DRB Application No.: **04DRB-01154 (P&F)**

Project Name: **SANDIA MANOR SUBDIVISION**

RE: Sandia Manor Subdivision, Lots 11, 12-A, 12-B & 13-A/minor plat

PLAT OF
 LOTS 12-A-1, 12-B-1 & 13-A-1, BLOCK 7
 SANDIA MANOR SUBDIVISION
 SECTION 23, T. 10 N., R. 4 E., N.M.P.M.
 CITY OF ALBUQUERQUE
 BERNALILLO COUNTY, NEW MEXICO
 JULY 2004
 SHEET 1 OF 2

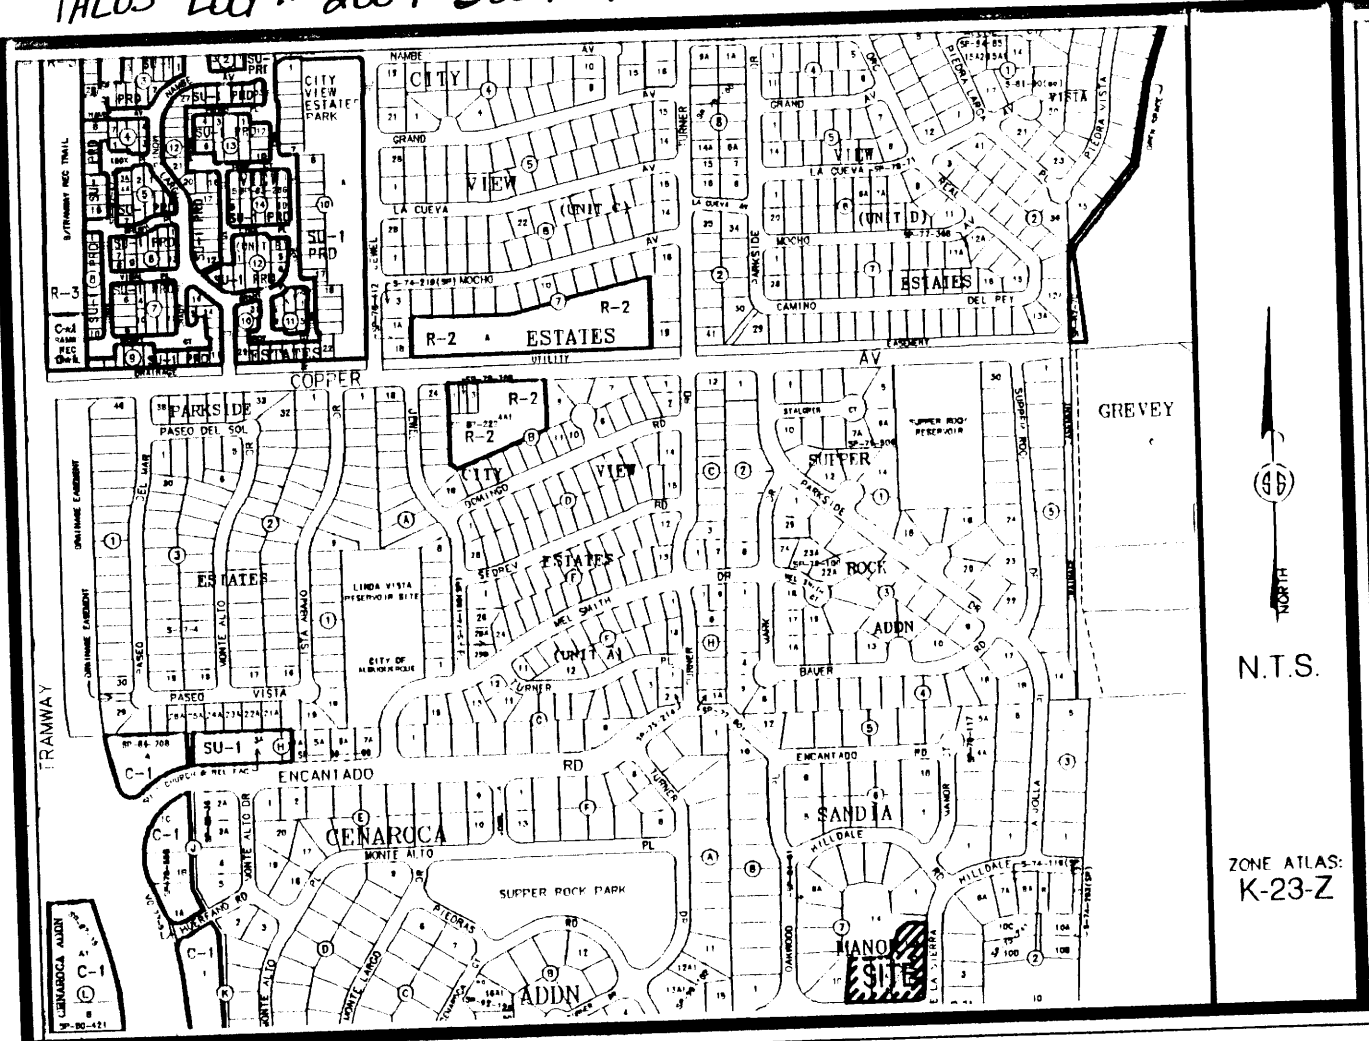
No objection once the current zoning is listed on the plat per the Subdivision Ordinance.
